**Planning Department
Transportation Development Services**

**Re: McDonalds, 6300 San Mateo Blvd.
Traffic Circulation Layout**
Architect's Stamp dated 11-05-14 (E18-DO19C)

Based upon the information provided in your submittal received 11-07-14, the above referenced plan cannot be approved for Building Permit until the following comments are addressed:

(REV 02/2013)

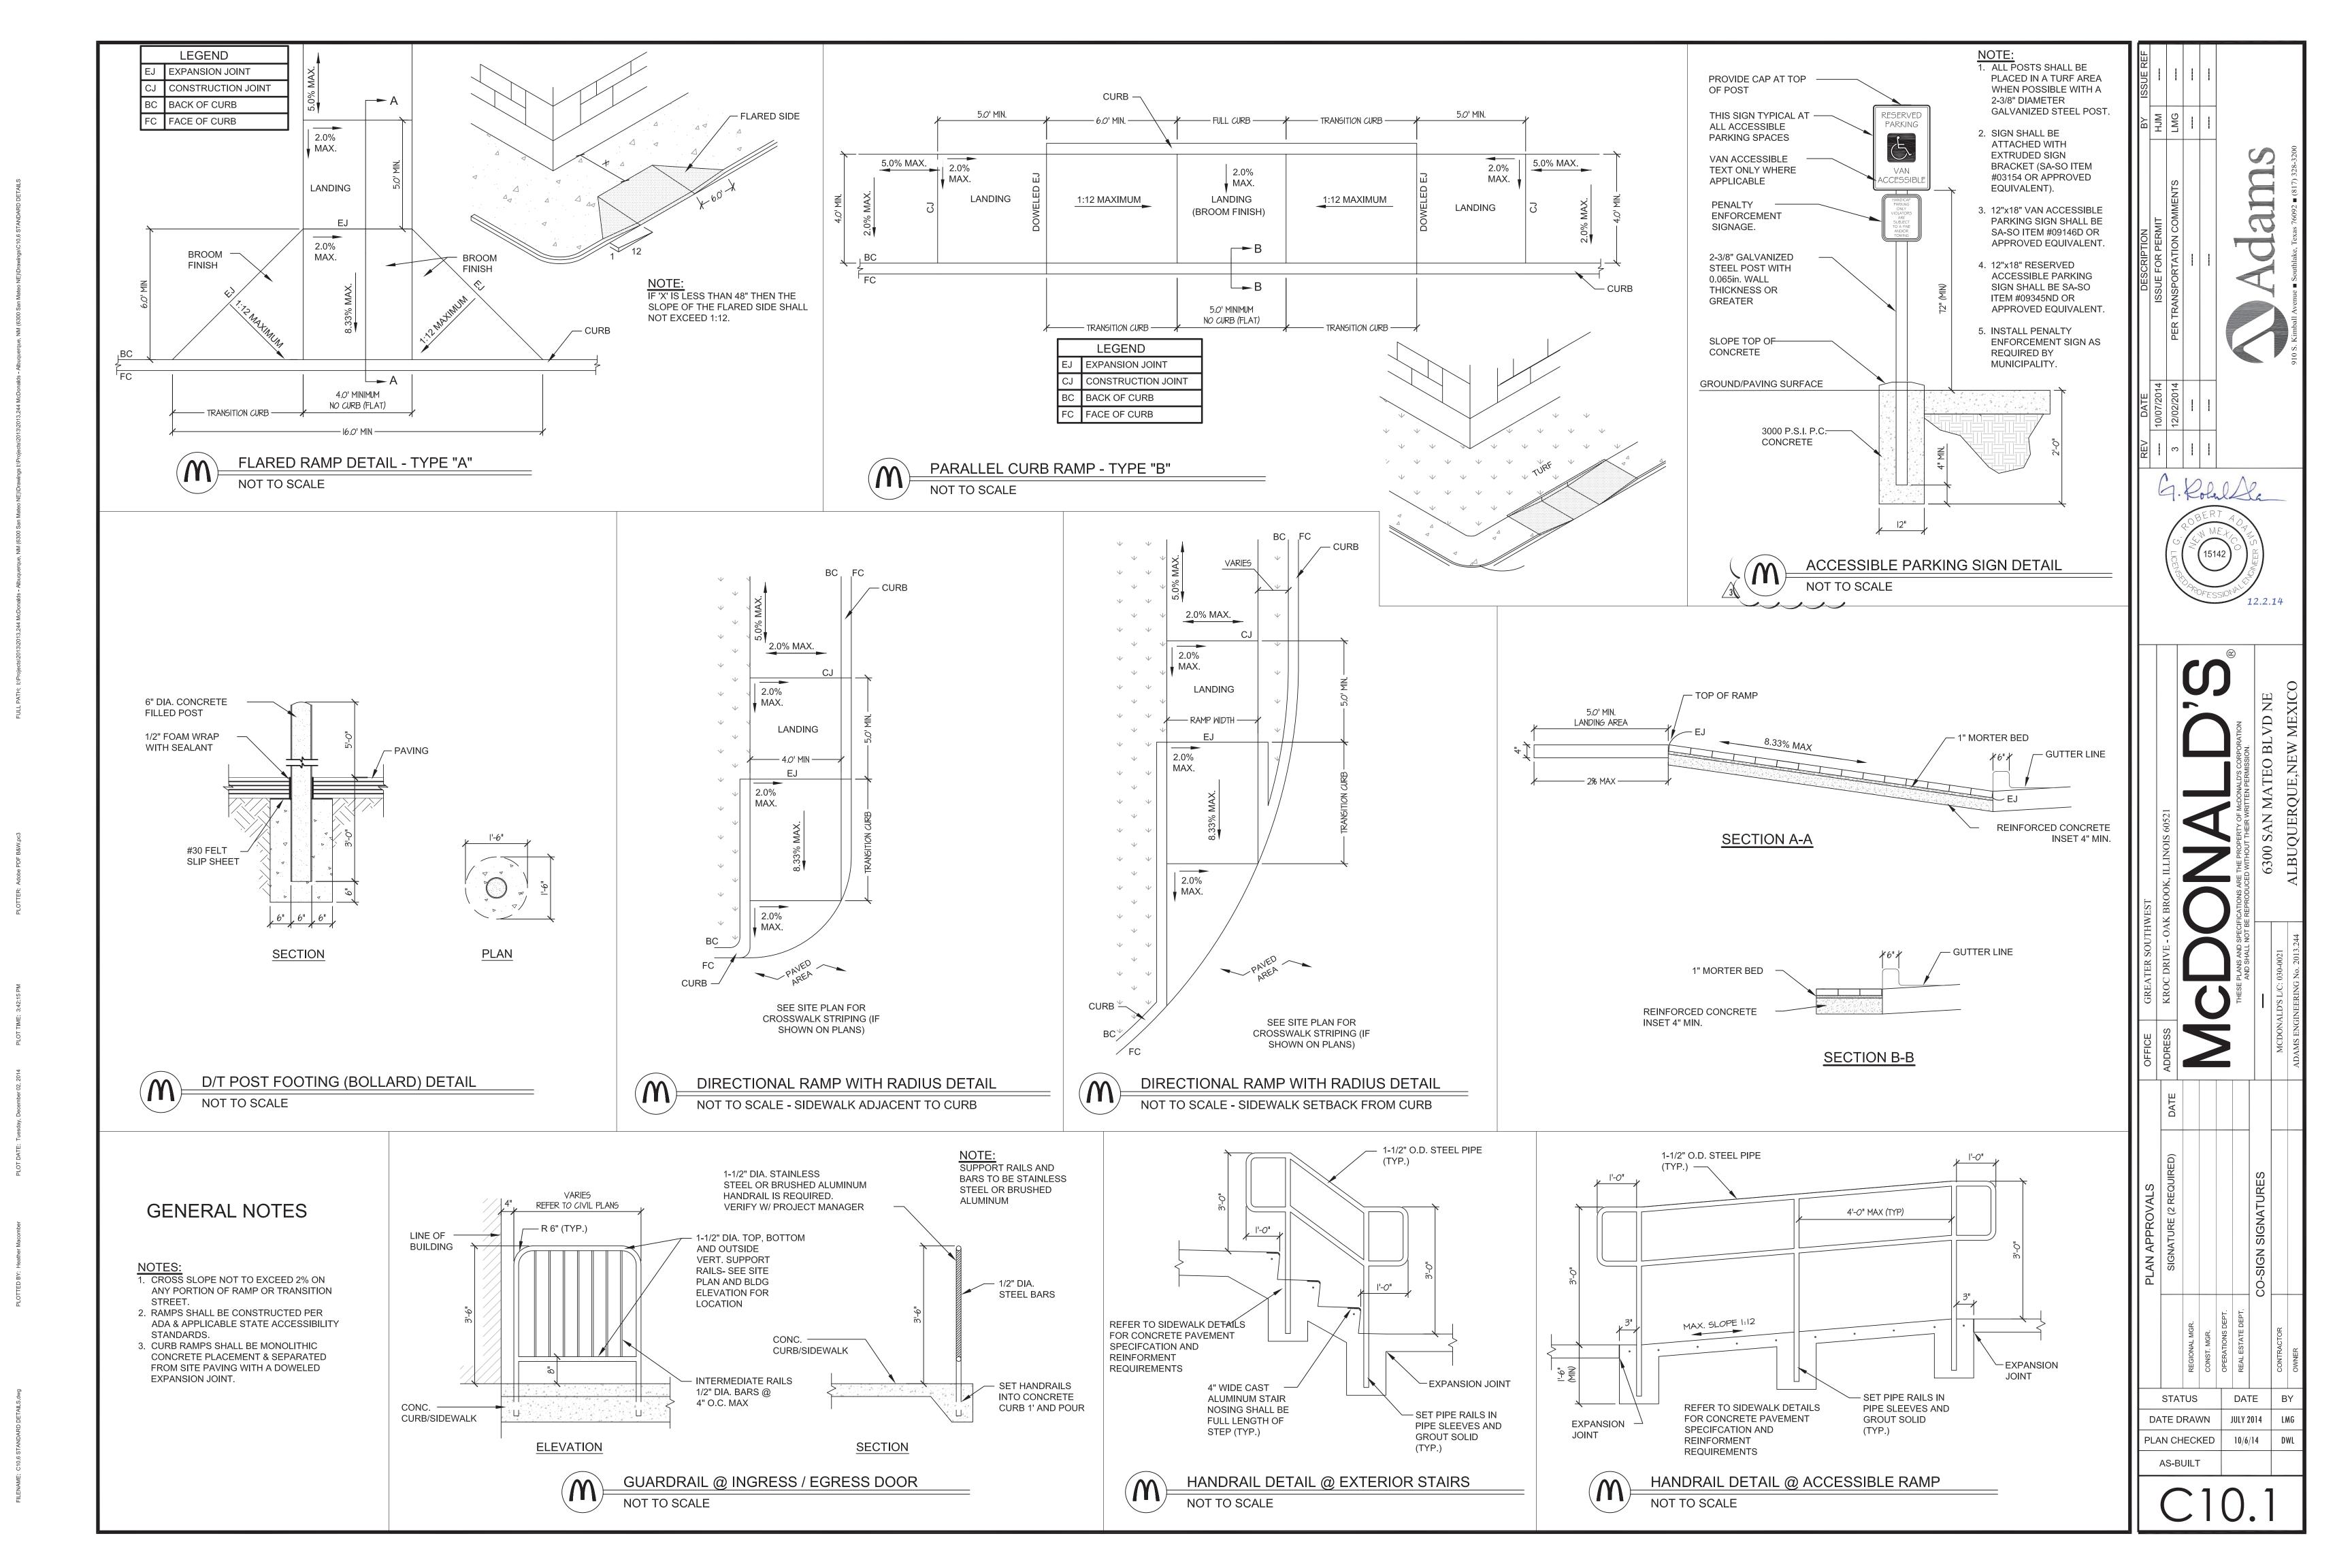
1. Label the McDonald's building as existing. Label width of existing sidewalk along San Mateo Boulevard. If some of the existing curb on the site is to remain, label the existing curb and curb height. (The curb height should be between 6 inches and 8 inches.)

2. List the width for all parking spaces. The minimum width for the parking spaces should be 8.5 feet. Also label the width of the handicap space on the south side of the parking lot.

3. The handicap accessible spaces must include an 8-foot wide van access aisle. Currently, the aisle shown is only 5 feet. Also, label the striping for the handicap accessible aisle and pathway.

4. Include an ADA van accessible sign. This sign must have the required language per 66-7-352.4C NMSA 1978 **"Violators Are Subject to a Fine and/or Towing."** (Provide sign detail on Sheet C10.1 as called out by Keyed Note 7 on the plan sheet.)

5. The 8-foot wide ADA access aisle shall have the words **"NO PARKING"** in capital letters, each of which shall be at least one foot high and at least two inches wide, placed at the rear of the parking space so as to be close to where an adjacent vehicle's rear tire would be placed. (66-1-4.1.B NMSA 1978)

6. Per the DPM, a minimum 6-foot wide ADA accessible pedestrian pathway is required from the public sidewalk to the building entrances. Please widen the existing handicap accessible pathway shown tying into the existing sidewalk at

7. A 6-inch to 8-inch high curb is required to separate the driving area and parking lot from the sidewalk and landscaped areas. Label the new curb as 6 inches or 8 inches.
8. Label both existing and proposed asphalt for the new parking lot.
9. Show the queue length for the drive-thru.
